# **OXFORDSHIRE COUNTY COUNCIL'S RESPONSE TO CONSULTATION ON THE FOLLOWING DEVELOPMENT PROPOSAL**

**Application no:** 16/00264/FUL

**Proposal:** Construction of a road with associated infrastructure within the Heyford Park development

**Date:** 31 March 2016

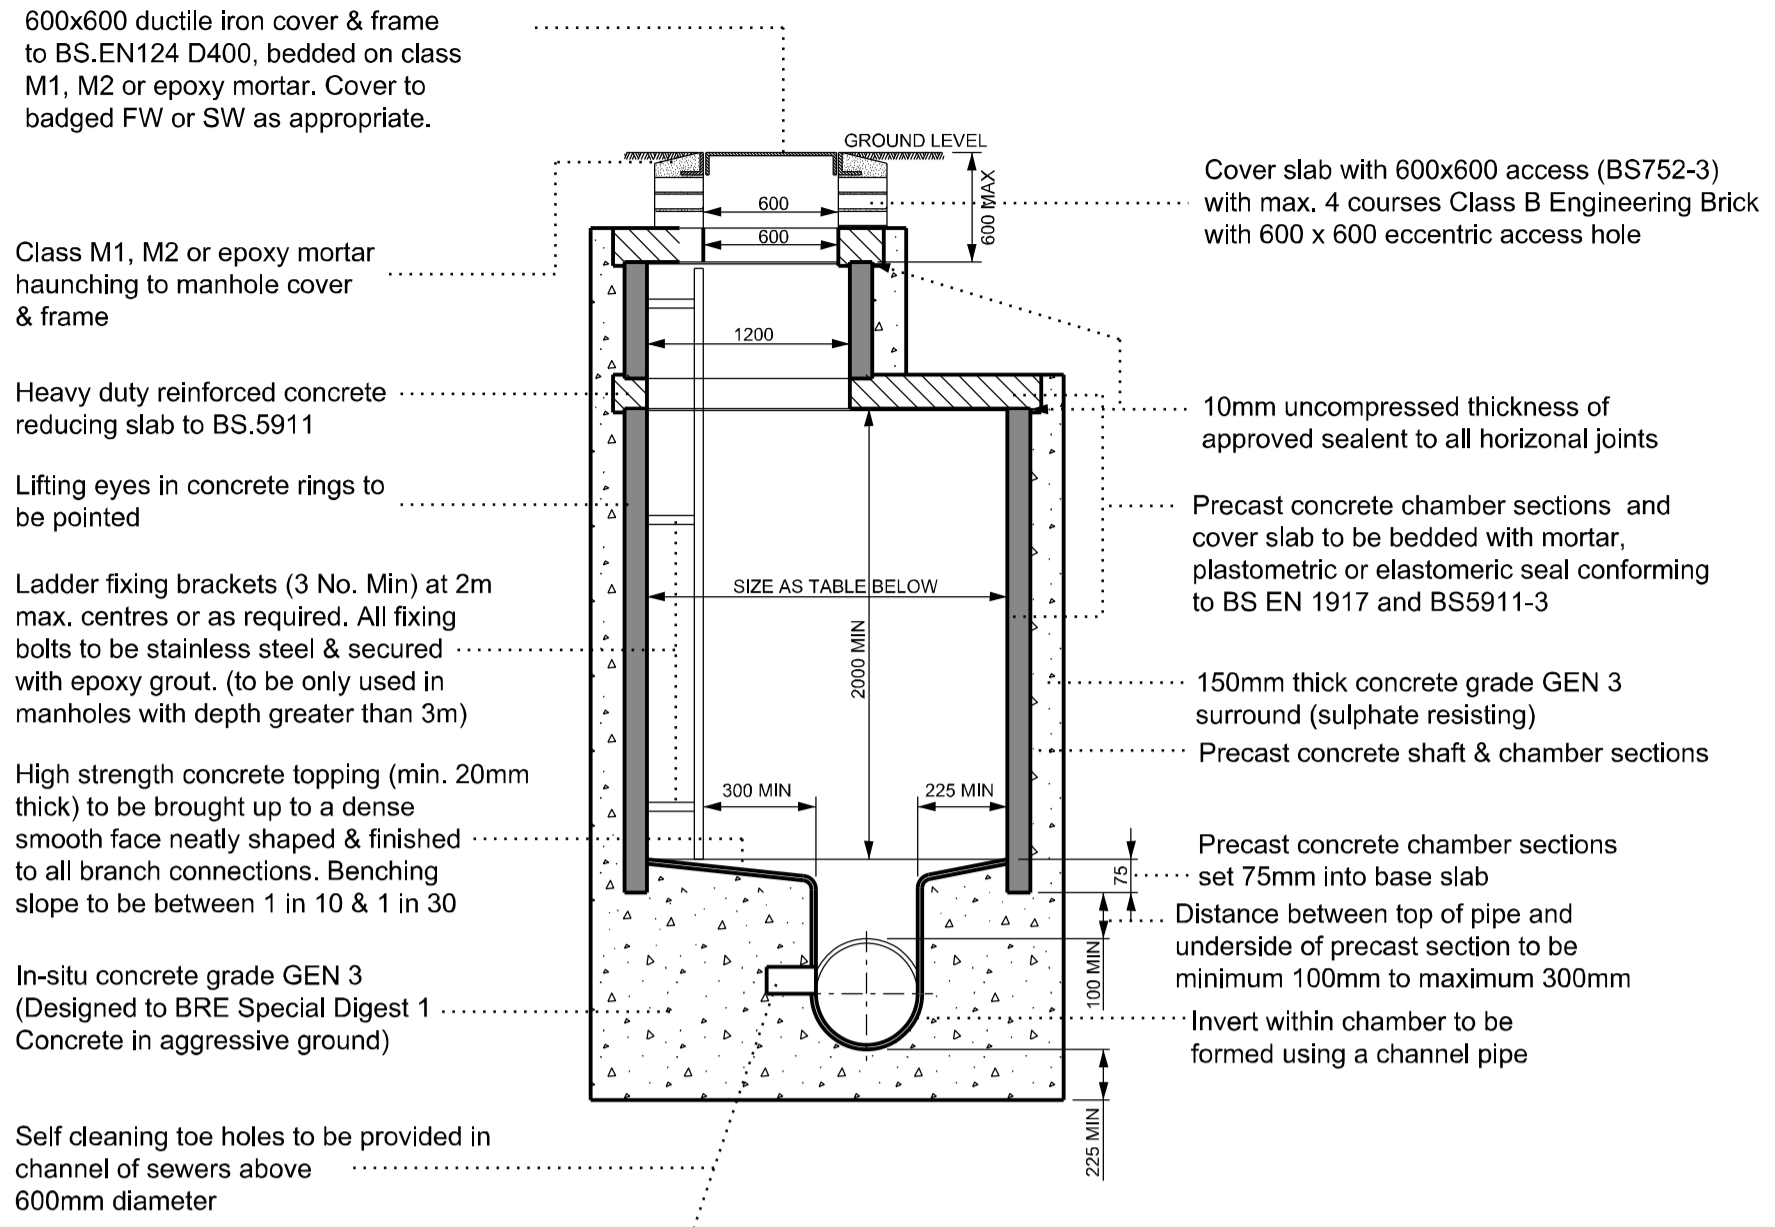
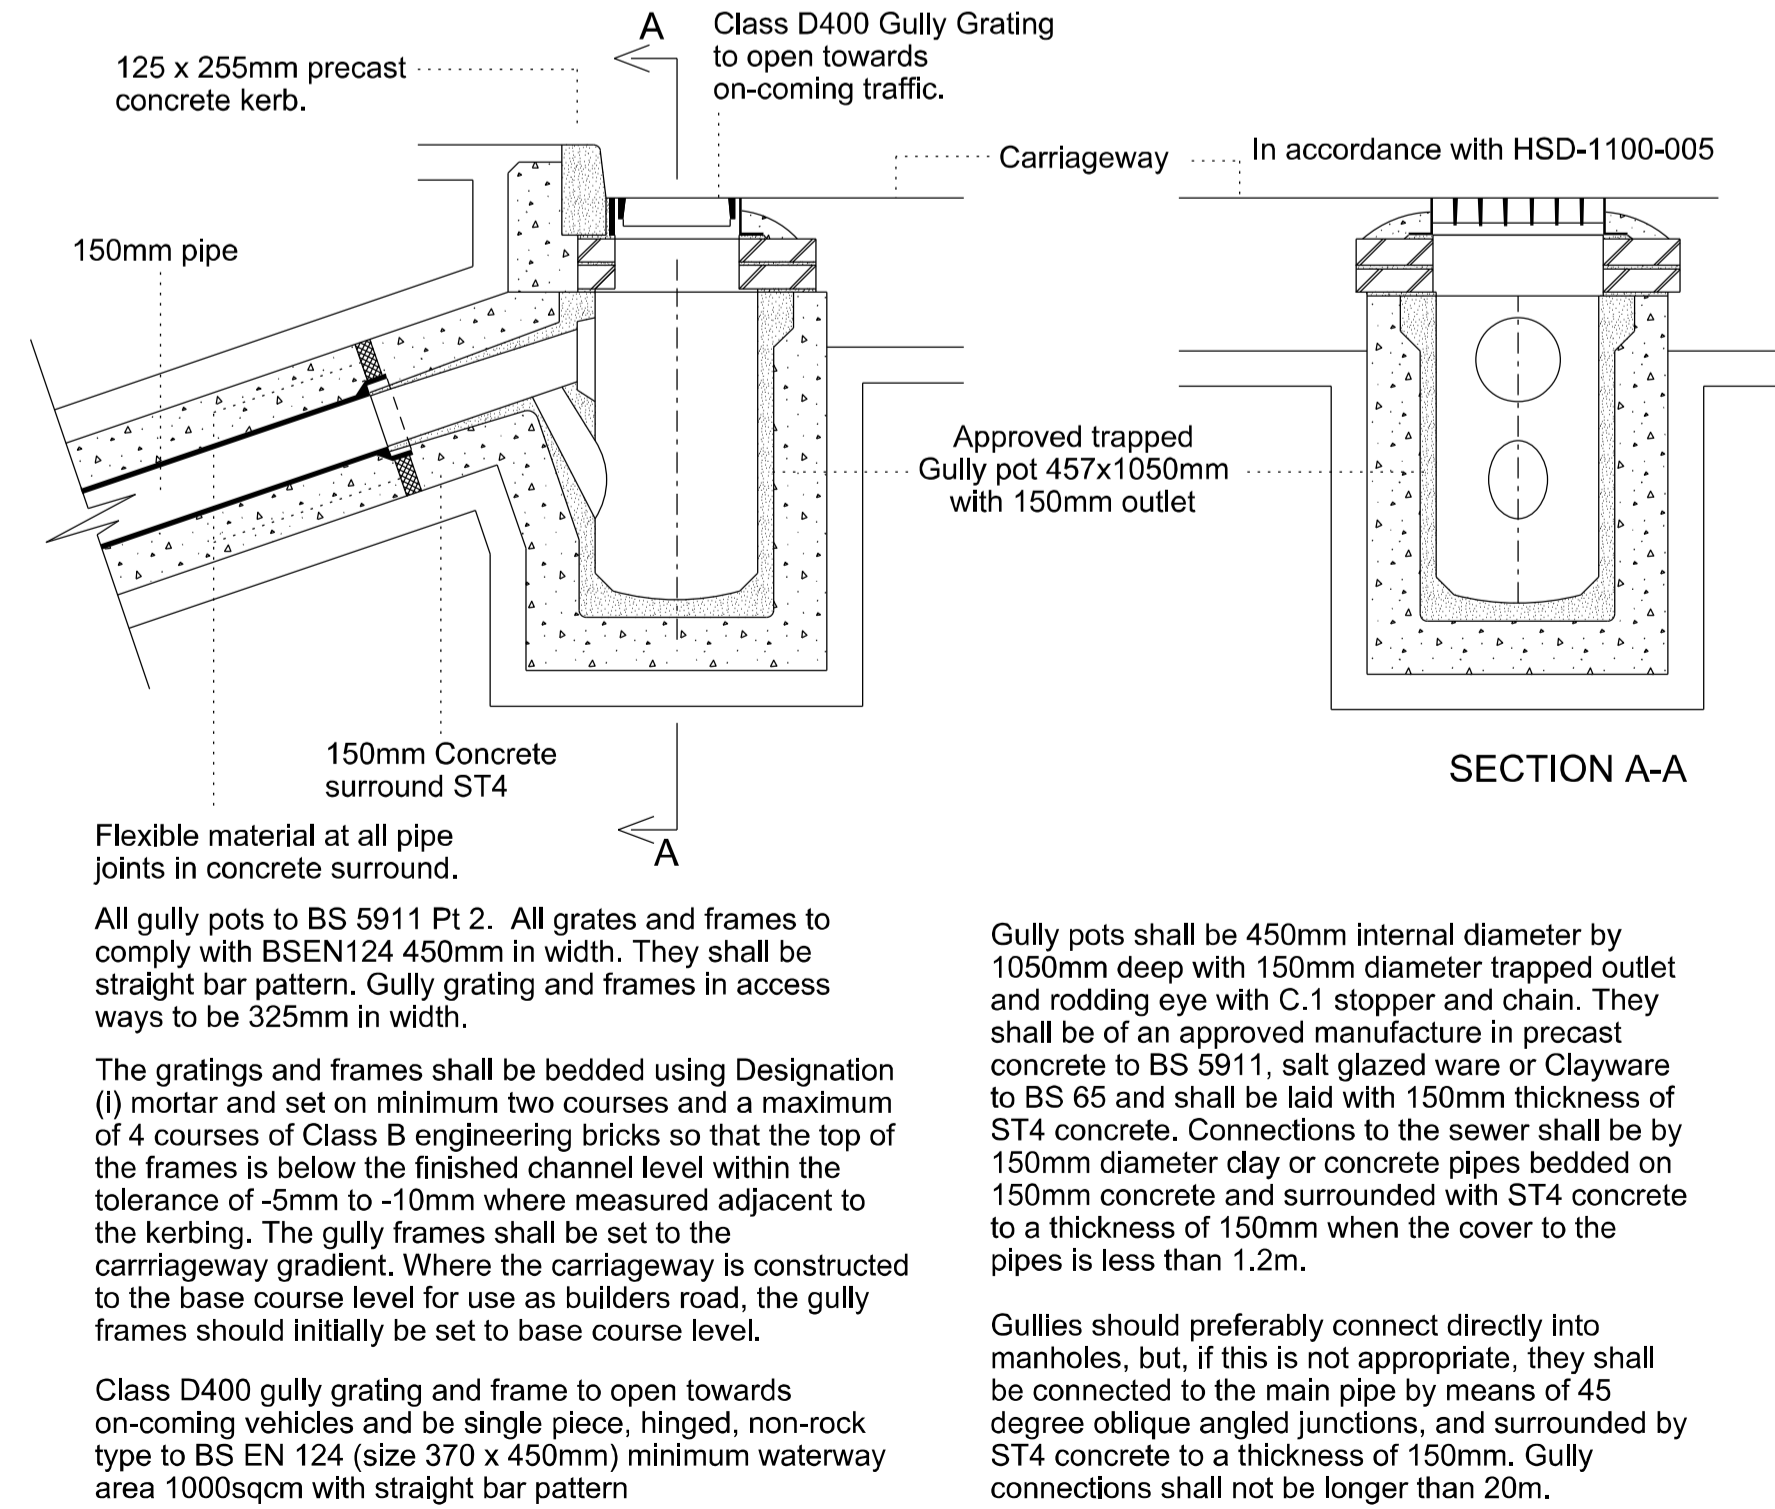
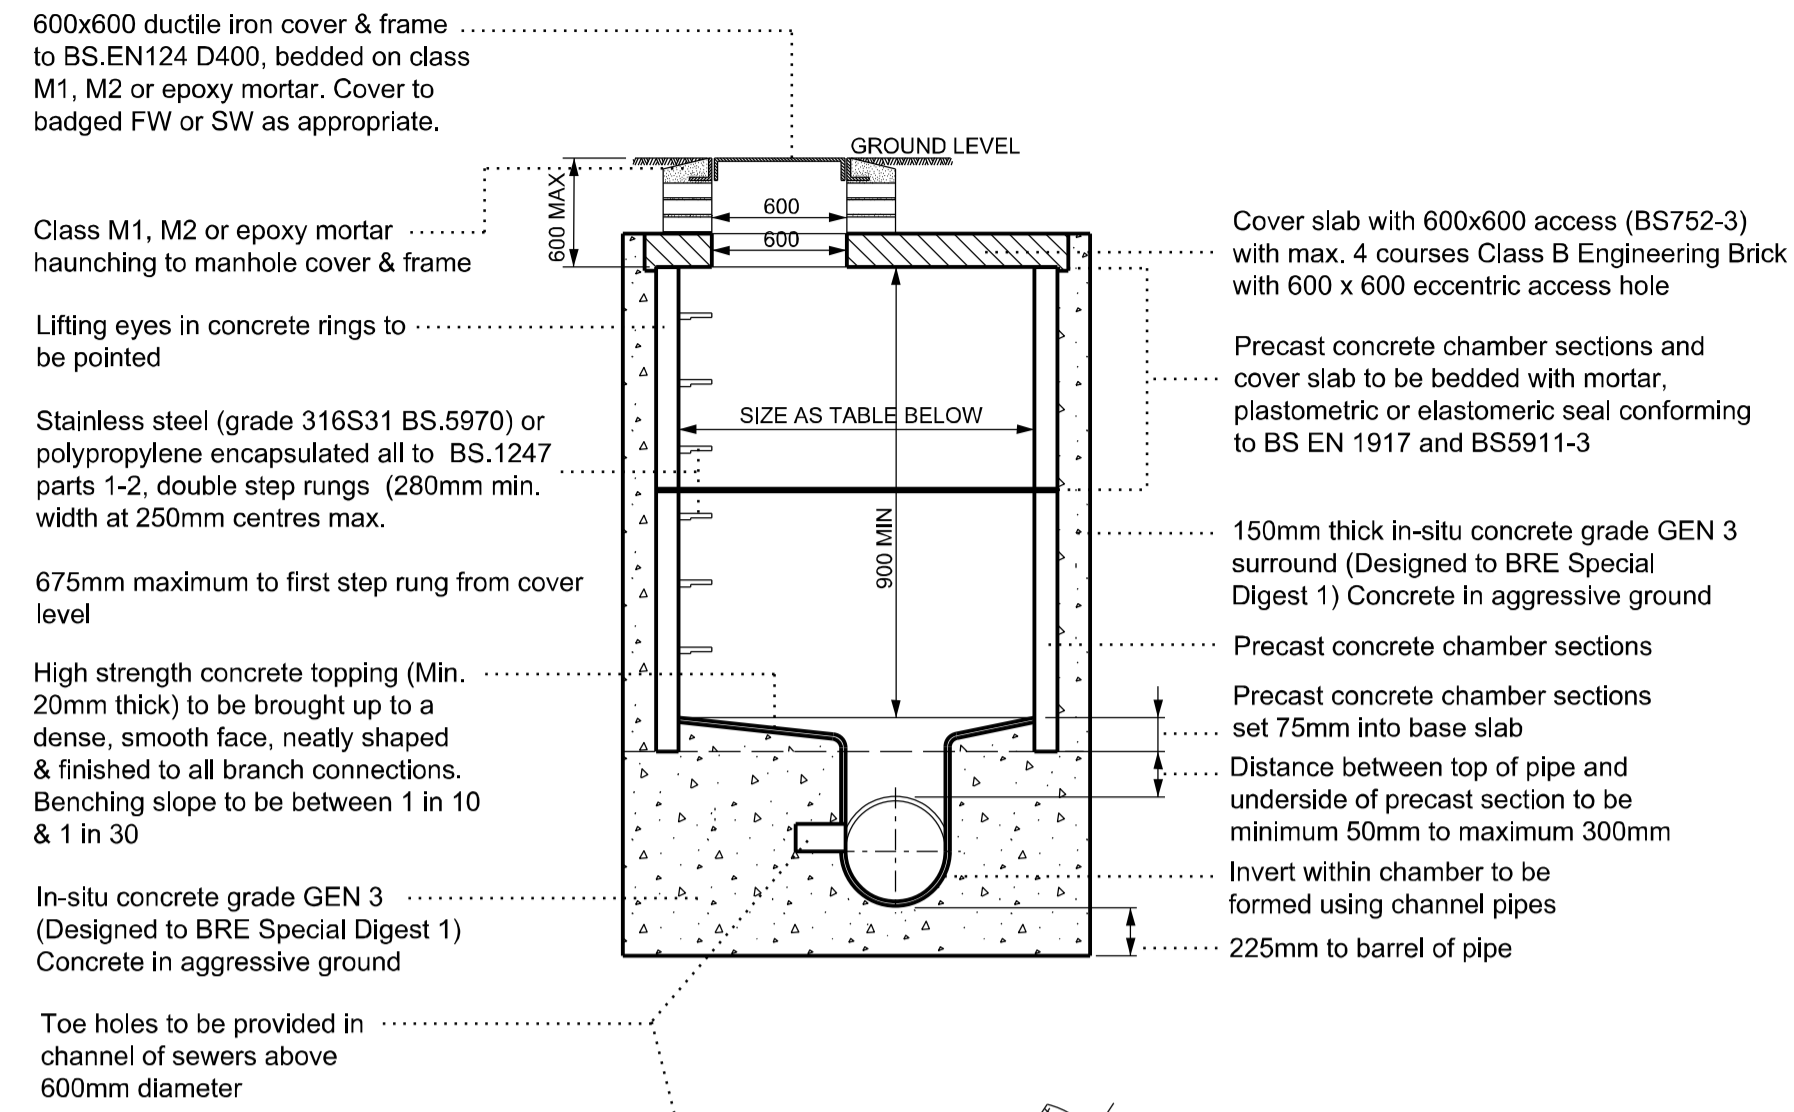
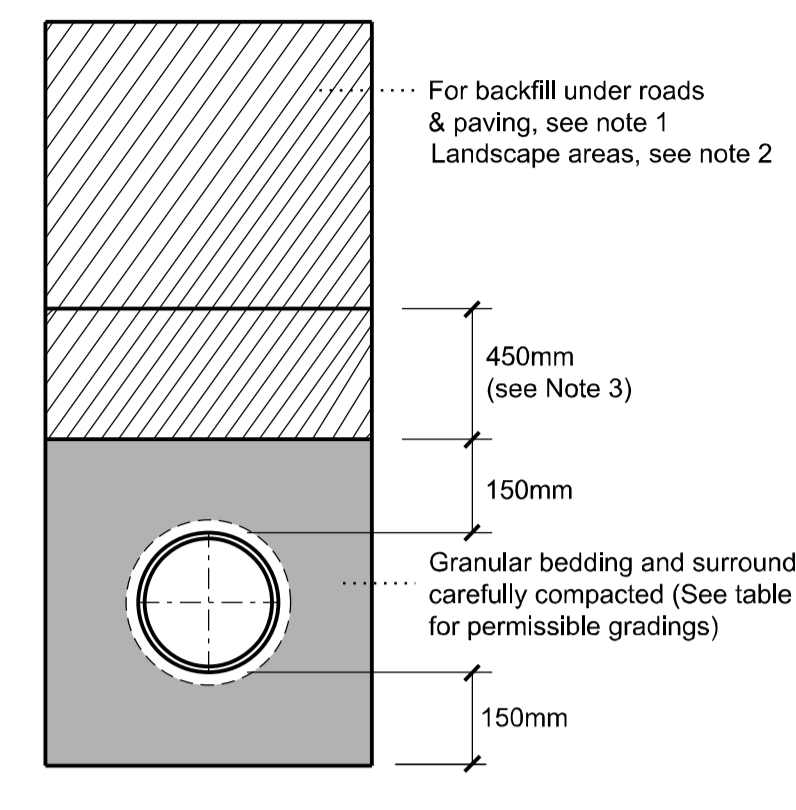
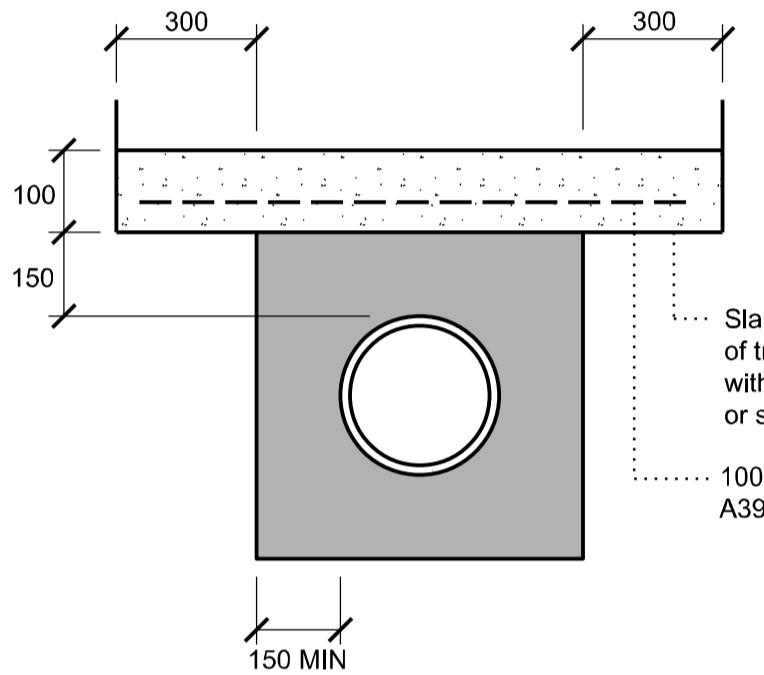
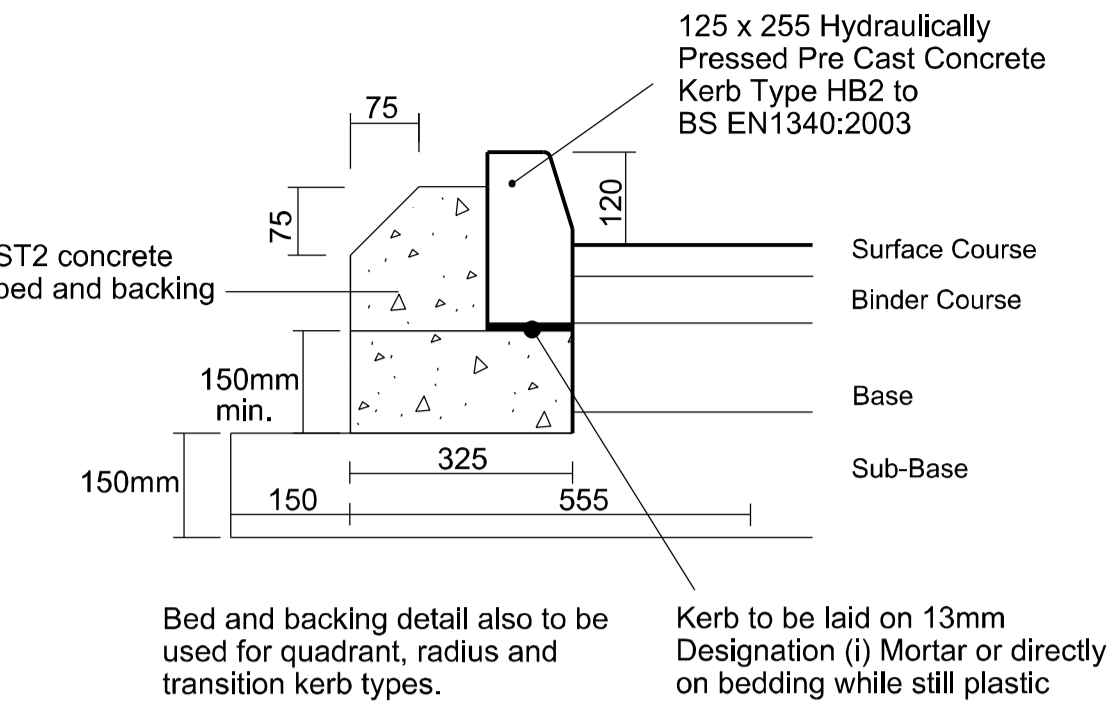
The specification on the Typical Construction Details plan No.HEYF/5/765 is to a previously approved standard and is therefore acceptable.
